NC DEPARTMENT OF
**HEALTH AND
HUMAN SERVICES**

Re: Project No. HL-11358-MAS/TKM
FID No. 120572
Good Hope Hospital
Psychiatric Bed Expansion
Erwin (Harnett)

The engineering portions of construction documents dated September 11, 2020 (received September 17, 2020) for the referenced project above have been reviewed for conformance with licensure rules for Hospitals (10A NCAC Chapter 13 Subchapter B). The engineering portions of the drawings are approved provided we receive satisfactory written responses and revised drawings that address the following comments:

1 ELECTRICAL POWER - FLOOR PLAN
1/8"=1'-0"

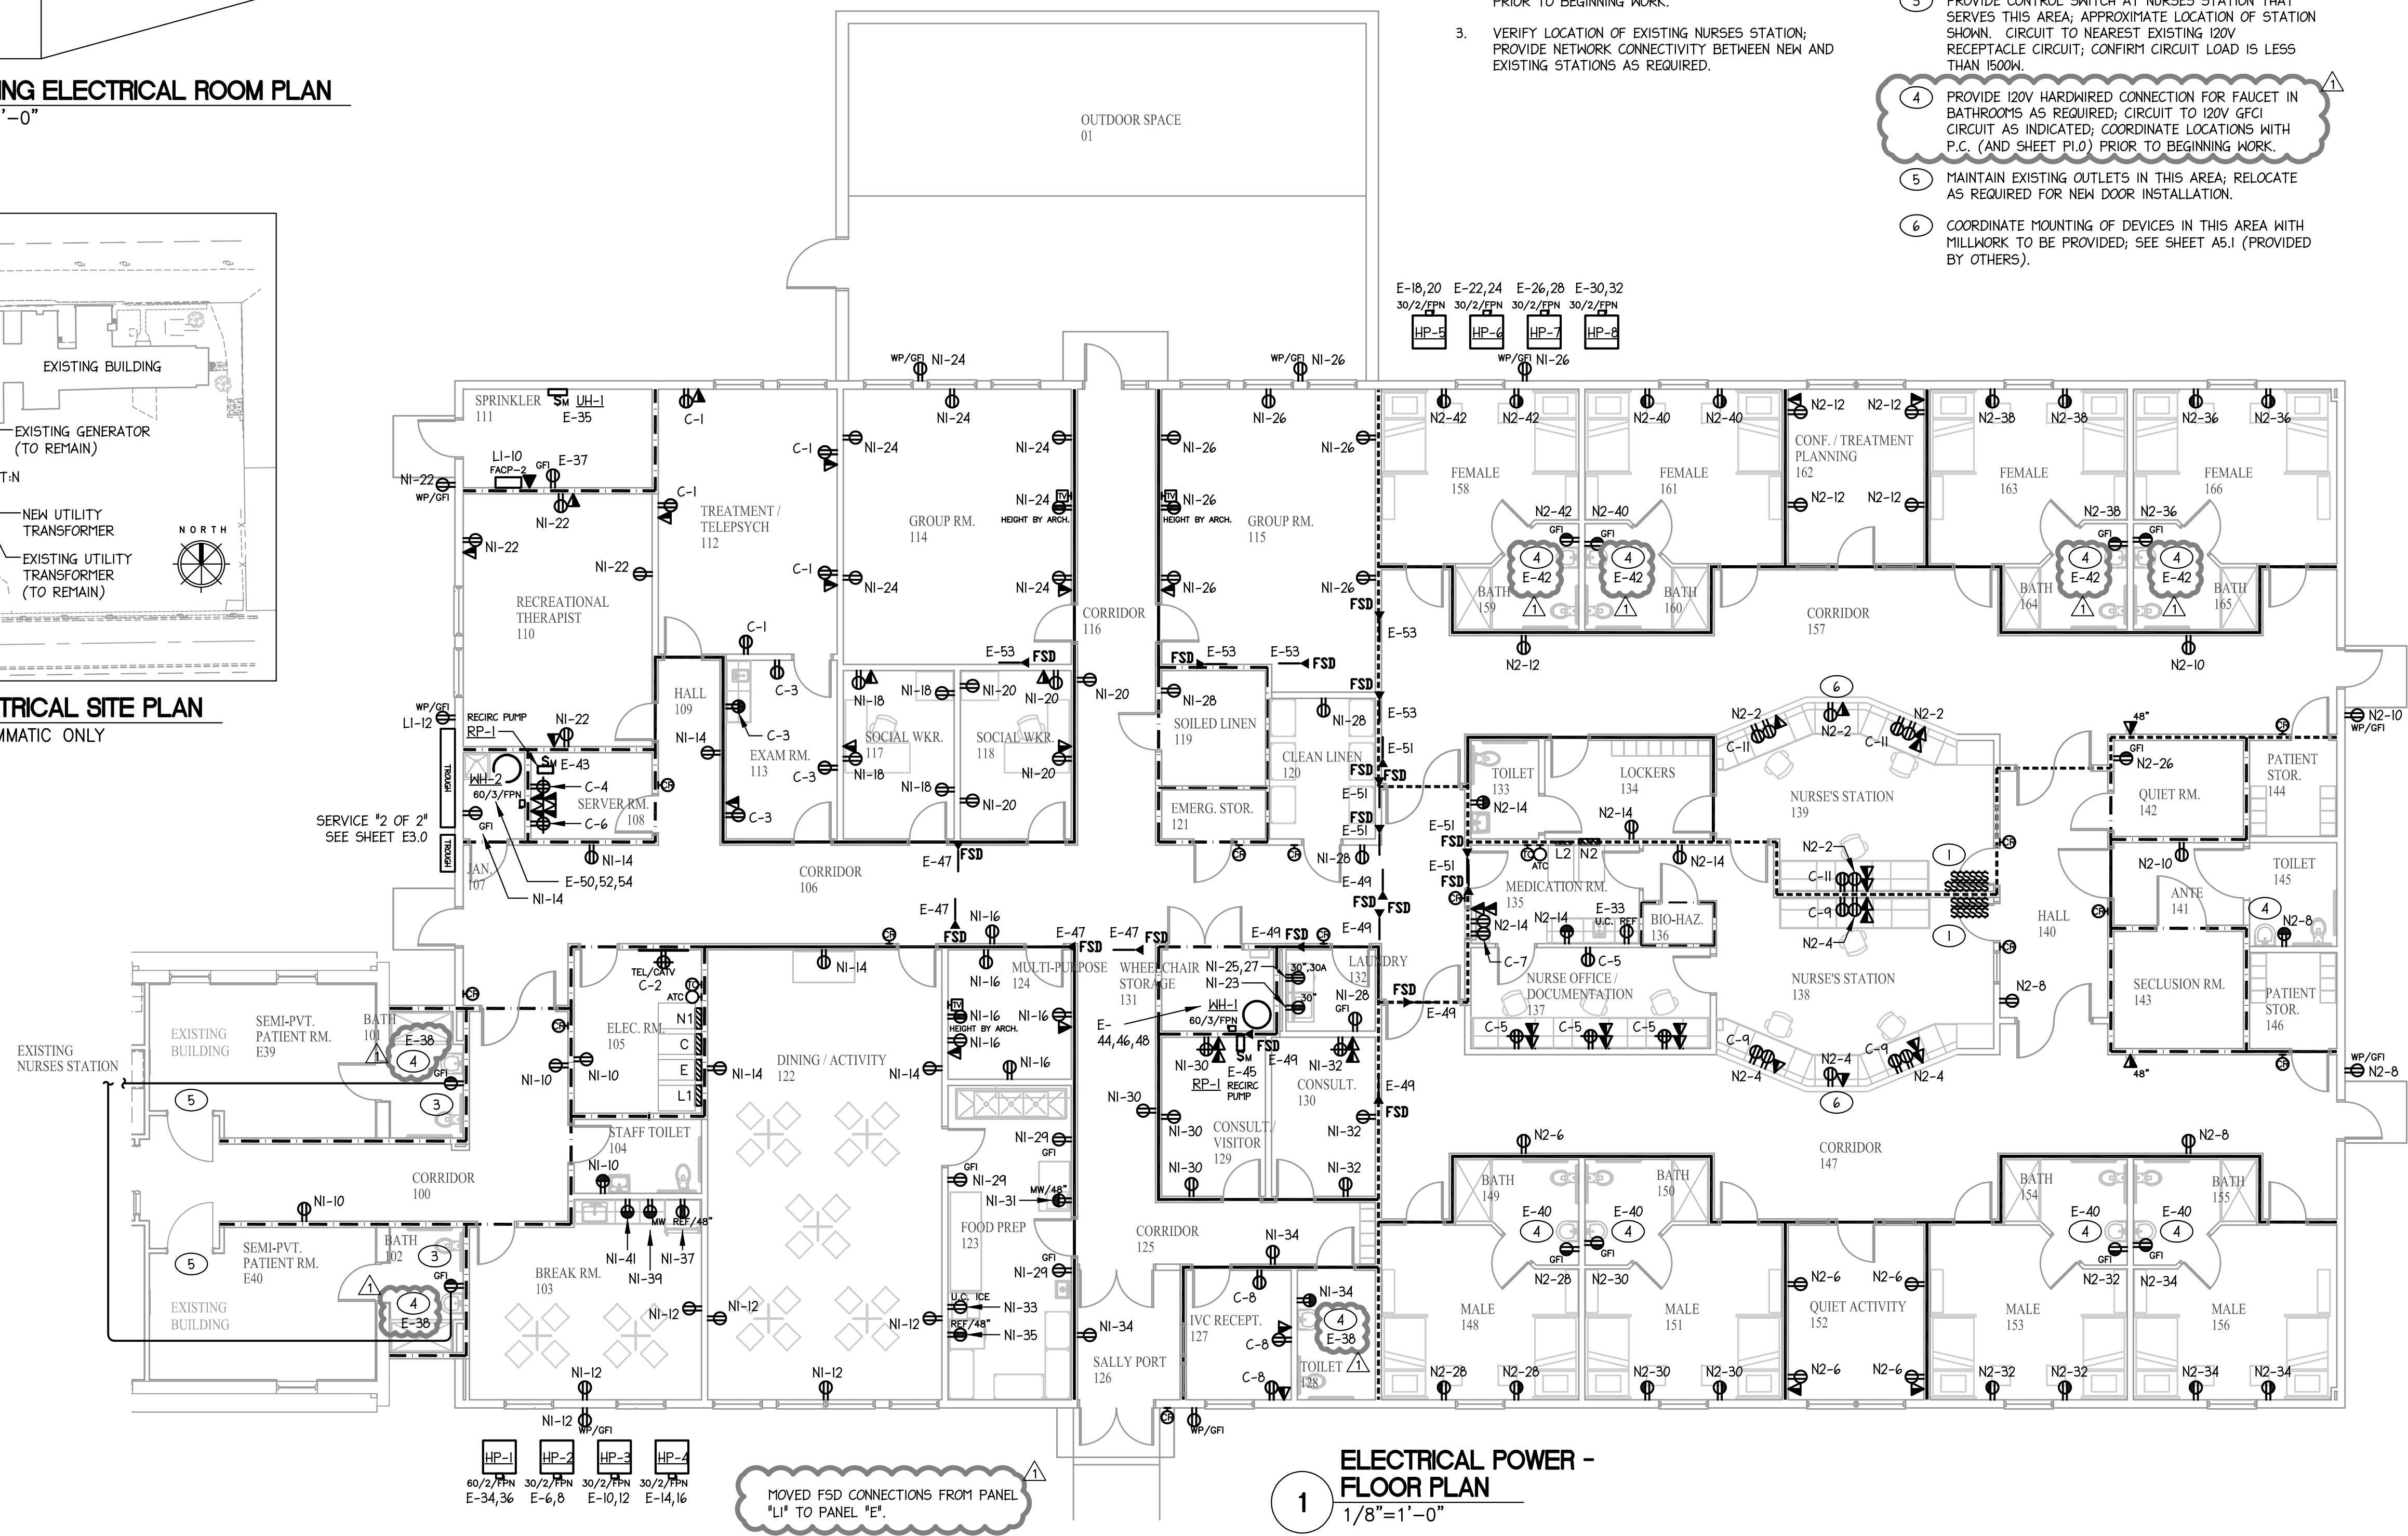
9. Reference Sheet E1.0: Tagged note #4 indicates electrical connection to nearest GFCI circuit for faucet. Electronic faucets shall be capable of functioning during loss of normal power. [2018 FGI, 2.1-8.4.3.2 (8) (b) (ii)] A normal circuit is shown serving these faucets. How will this requirement be met?

1 FIRE ALARM - FLOOR PLAN
 1/8"=1'-0"

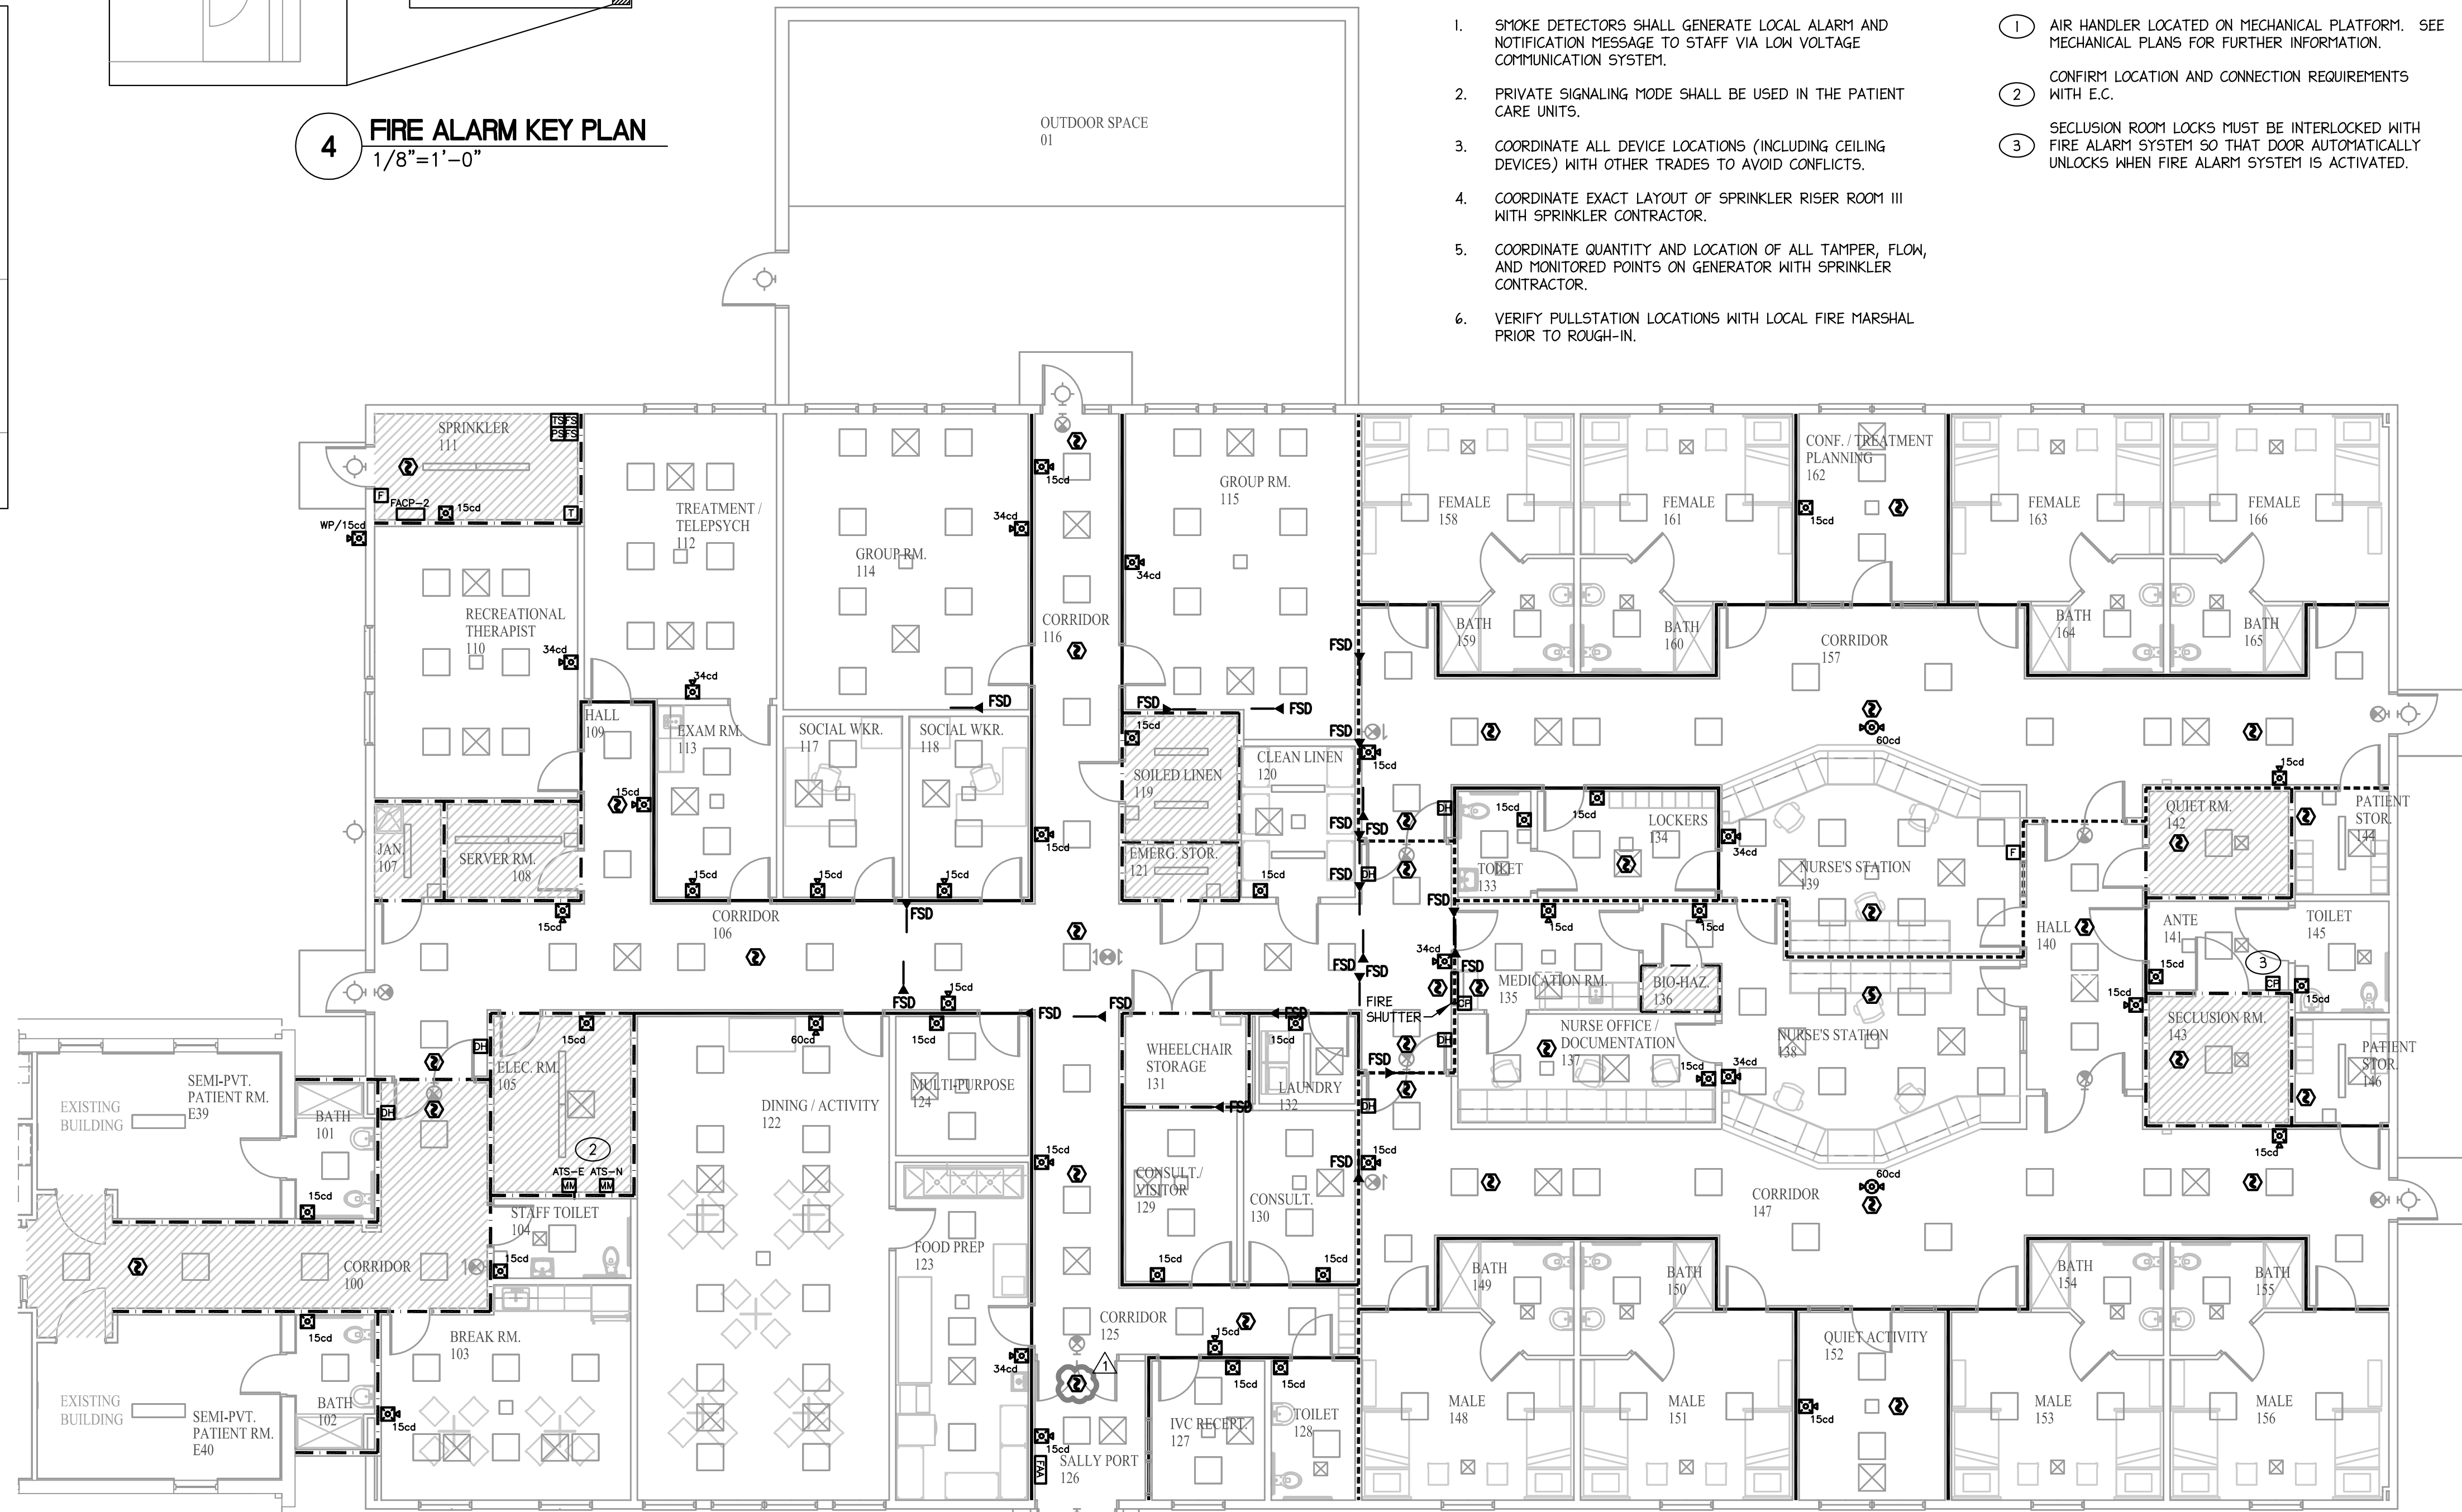
16. Reference Sheet FA1.0: Install a smoke detector in Sally Port 126.
